DECISION DELEGATED TO DEVELOPMENT MANAGER

Application No: H18-0886-18 **Applicant:** Mr & Mrs Hoyles

Proposal: Convert existing disused barn to provide four-bed two-storey dwelling with extension for daily management, operation and security of established agricultural facility

Location: Barn Adj: Westmere Farm Off New Road Sutton Bridge

PROPOSED GROUND FLOOR PLAN
SCALE: 1:50

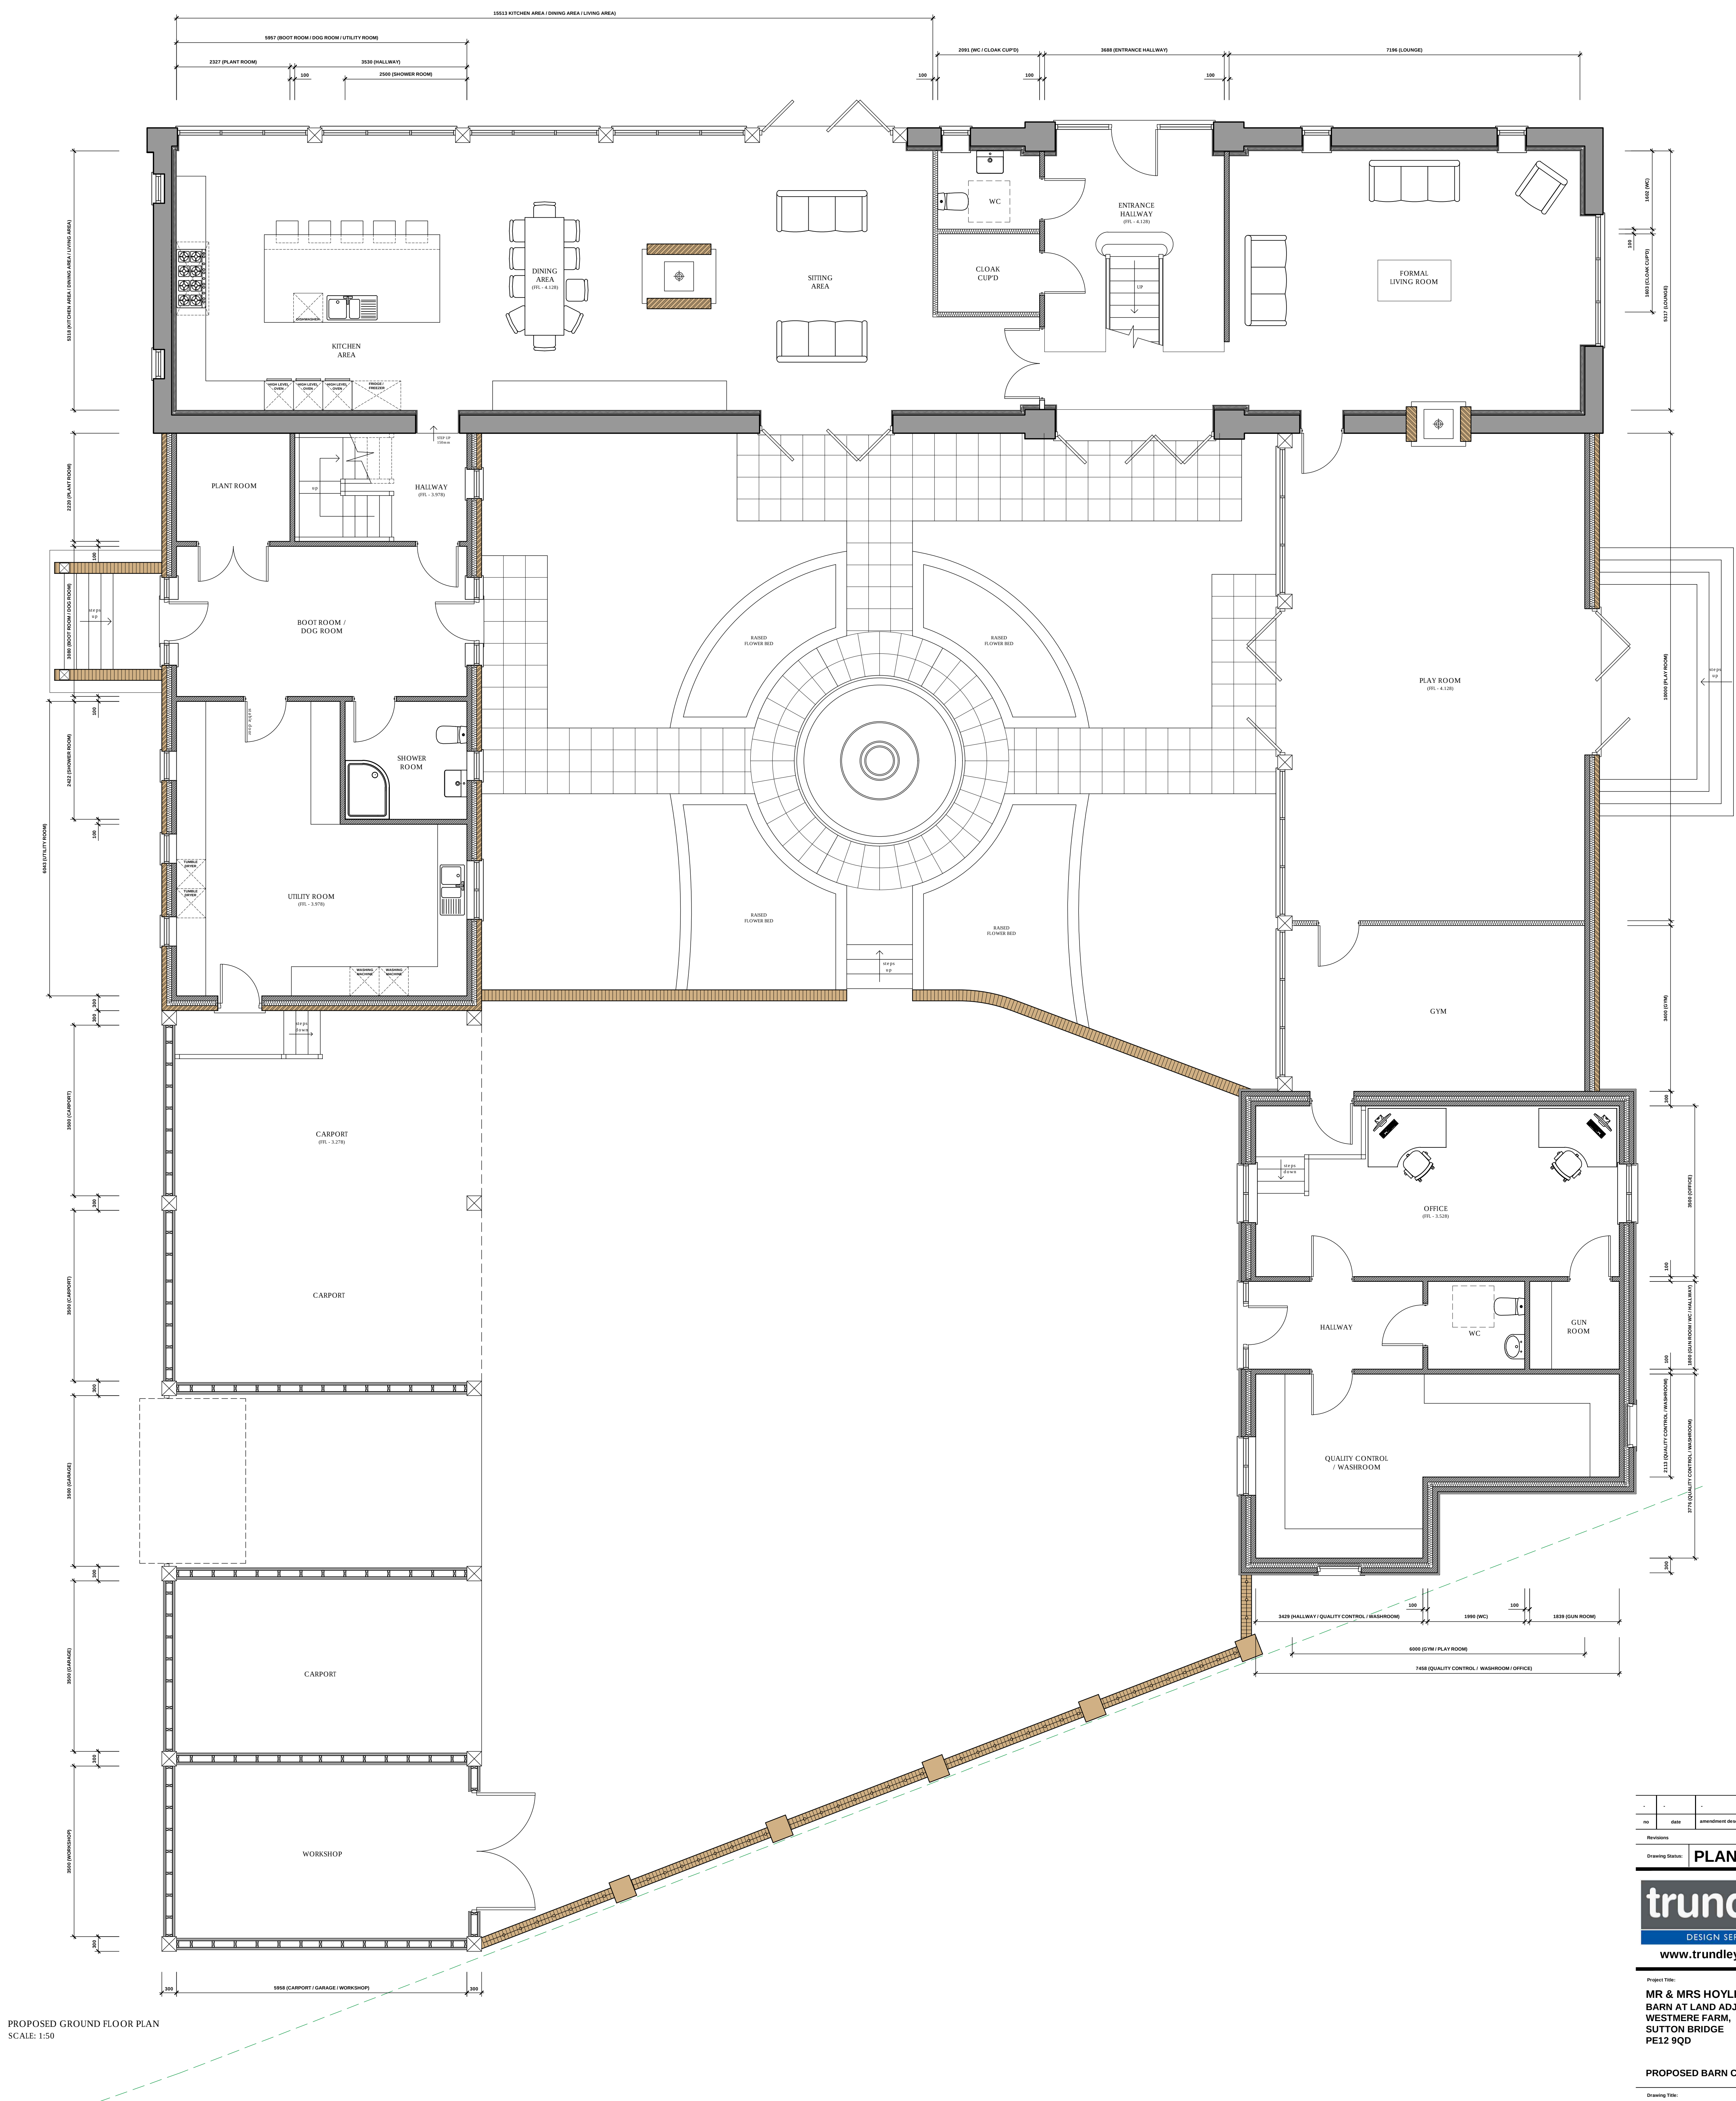
The applicant's agent has indicated that the office and quality control room would be used mainly by the occupants, Mr & Mrs Hoyles, and that the employees would mostly be located at the main operational/storage buildings. The office itself is located on the eastern side of the building. It is considered that the proposal would not materially harm the amenity of nearby residents in terms of noise/disturbance, etc. Although it is appreciated that there may be some disturbance during the construction phase it would be temporary.

PROPOSED FRONT ELEVATION
SCALE: 1:100

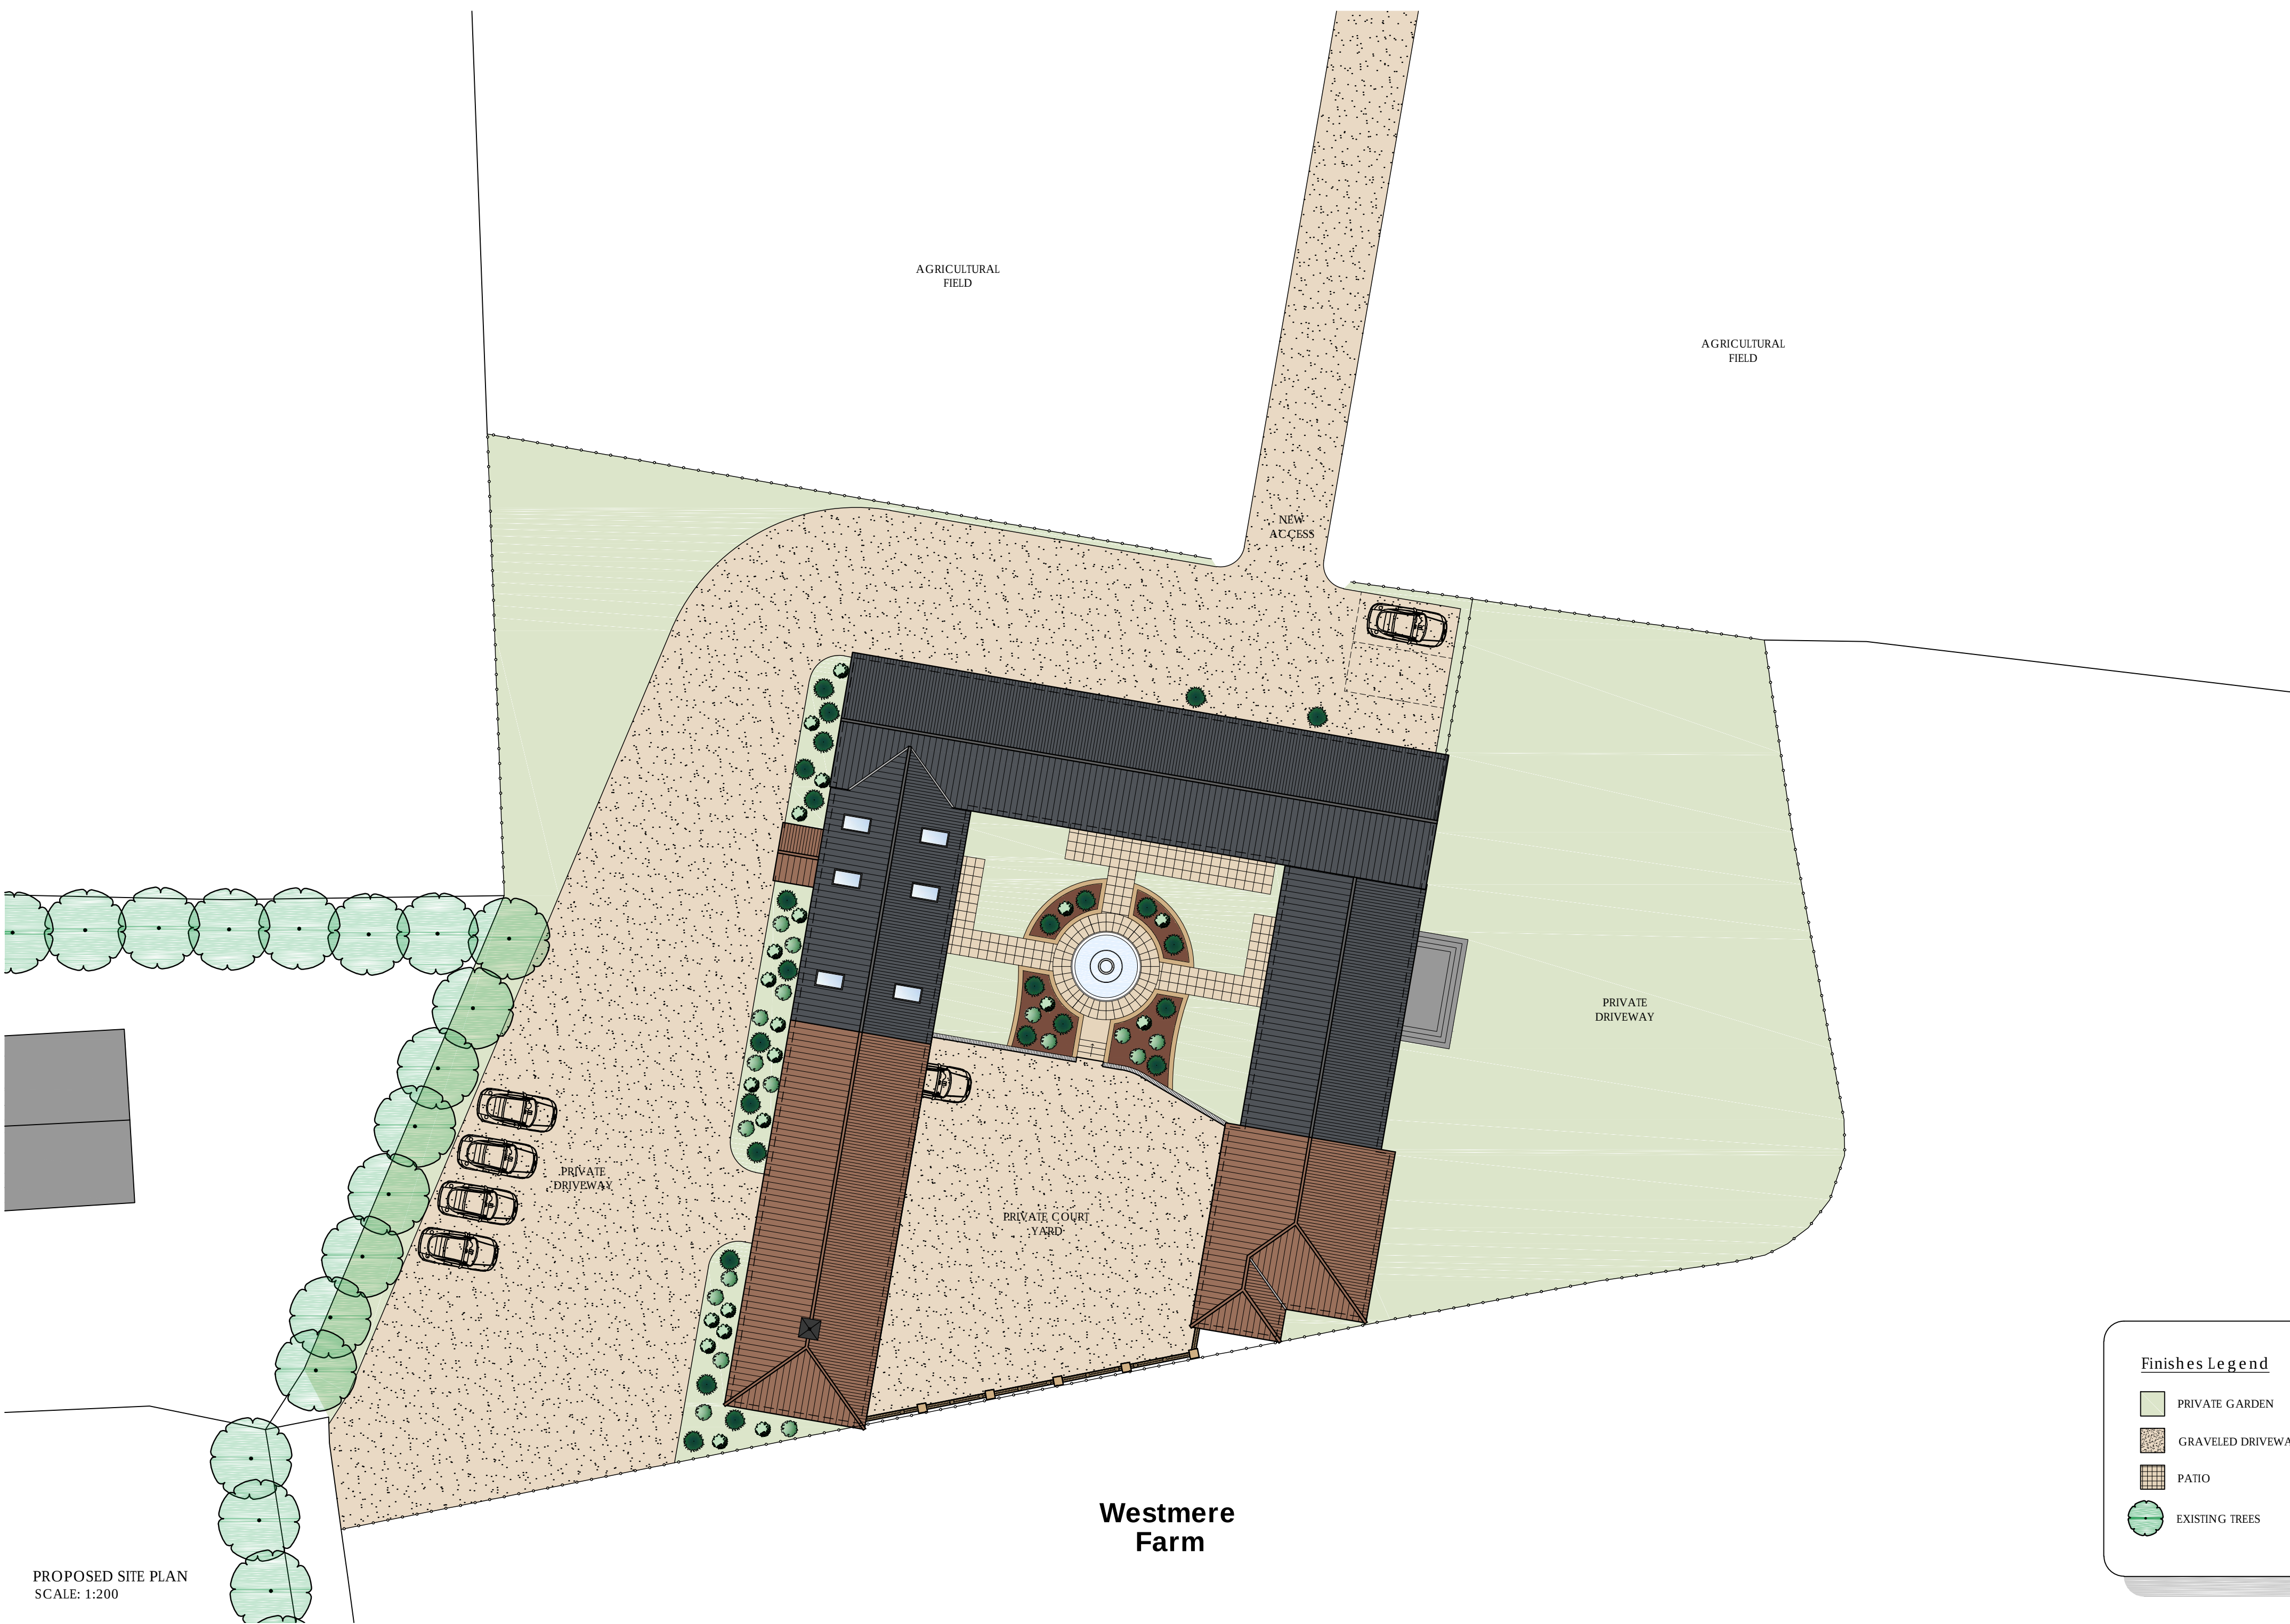
The nearest residential dwelling is Westmere Farm House to the west, which is accessed via a long private roadway off Bridge Road. The proposal does not have any major windows on its western elevation and is not close to the common boundary with Westmere Farm House. Moreover, the common boundary with the latter is delineated with a high Leylandii hedge. It is considered that the amenity of neighbouring residents would not be materially harmed in terms of overlooking, lack of privacy, overshadowing, light pollution, etc.
